Drawing Title	METROLINK - GENERAL ARRANGEMENT SEATOWN (SHEET 1 OF 3)		Drawing Status	S1
Drawing N°	ML1-JAI-ARD-ROUT_XX-DR-Y-03012	Plan Drawing N°	ML-RO 301 H-J	
Scales Original Size A1	AS SHOWN	Sheet	1	of 1

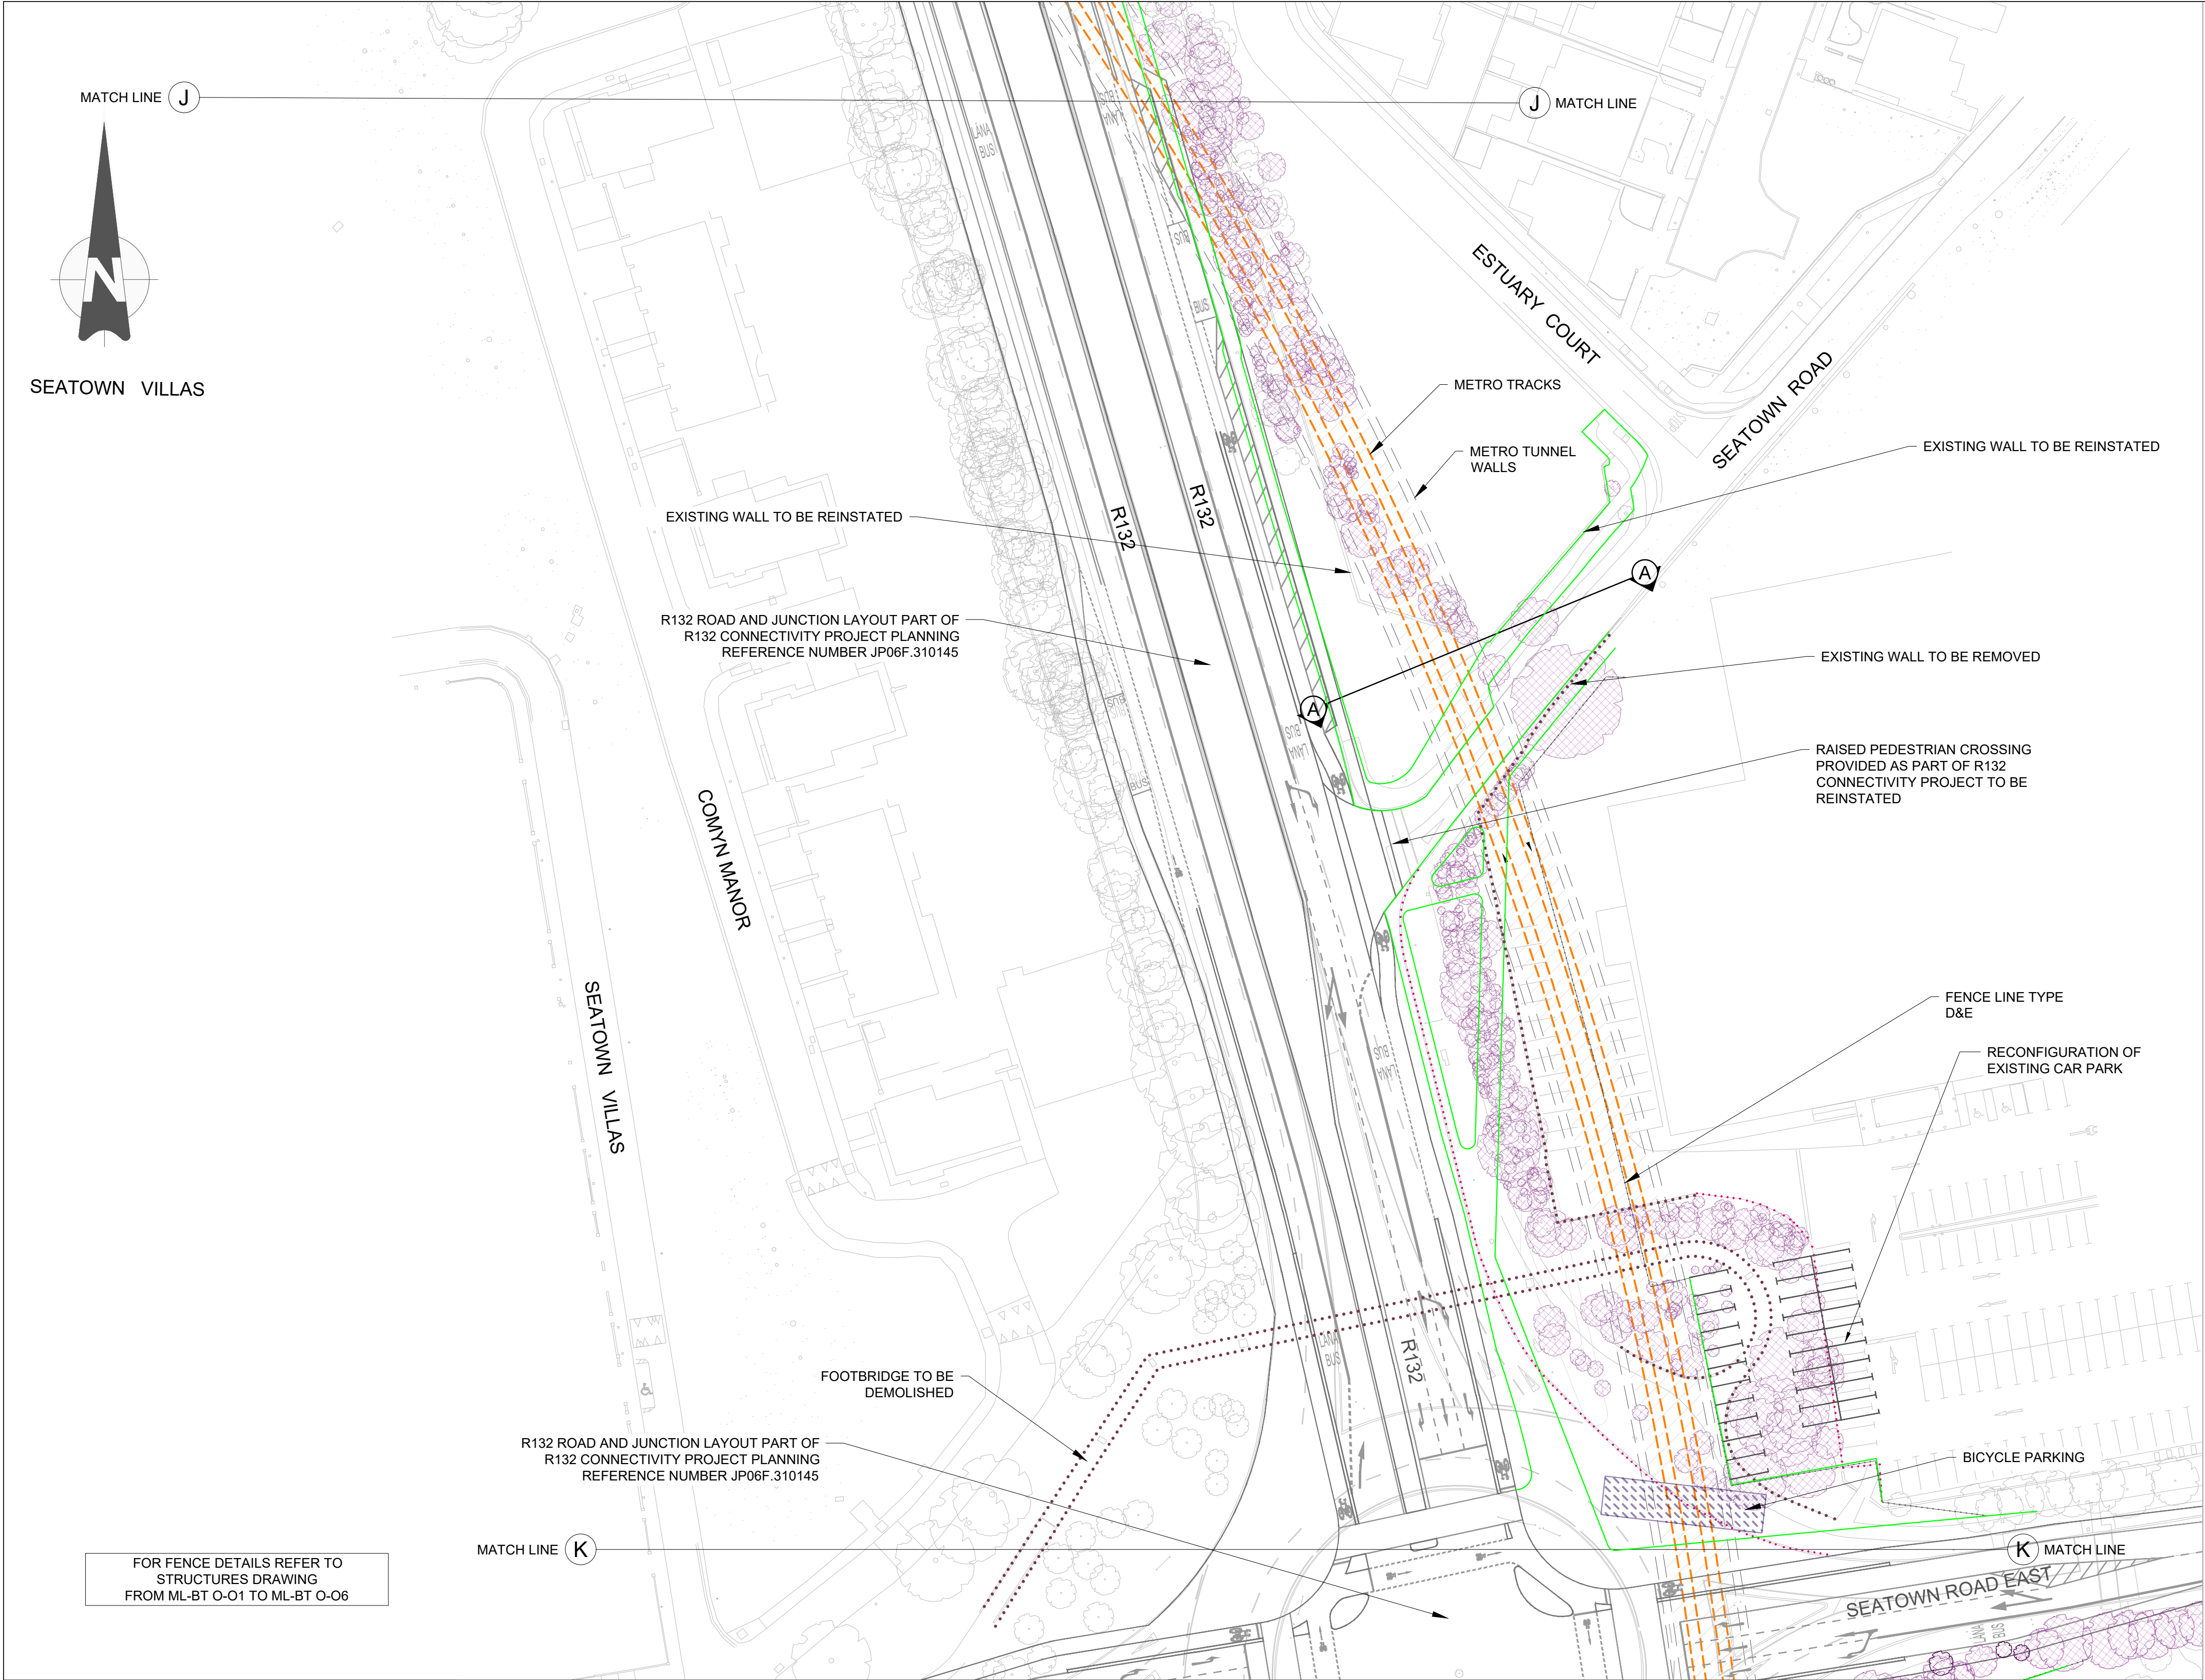
7	Proposed plans for the estate	7	<p>While there have been various iterations of the drawings we have seen for the estate, the latest ones as included in the railway order application, clearly show that despite all our discussions regarding the Metro line, our estate is being radically altered and will lose its overall look and feel and much of the existing amenity and sense of security associated with the green space, should the plan go ahead without alteration.</p> <ul style="list-style-type: none">• A significant number of additional walkways are planned throughout the green area (an increase from 3 to 9 walkways) which will substantially reduce the actual useable green area.• The volume and placement of new trees and shrubs severely impacts upon the useful play area of the estate (e.g., no adequate space for children to play football or other games).	See response number (1) above

10	Alternatives	10	<p>Cont.,,,</p> <ul style="list-style-type: none">• Opening in boundary wail - Replicate the current 2 openings in said wall with one at the proposed toucan crossing along the R132, thereby retaining safe access to and from the Swords side of Chapel Lane, and one at the exit to the R132 to allow for foot traffic to access the crossing at the new junction replacing the Malahide roundabout.• Footbridge across the R132 - While realising that there may be some engineering implications relative to the Metro line itself, we can concede that its retention on this specific basis may not be possible. However, we would suggest that the footbridge be retained as it provides a much safer access route across the R132 rather than a Toucan crossing. We say this based on consideration for the most vulnerable members of our community and indeed to retain such safety benefits for the whole community of swords that use this bridge daily.	Addressed in response number (8).
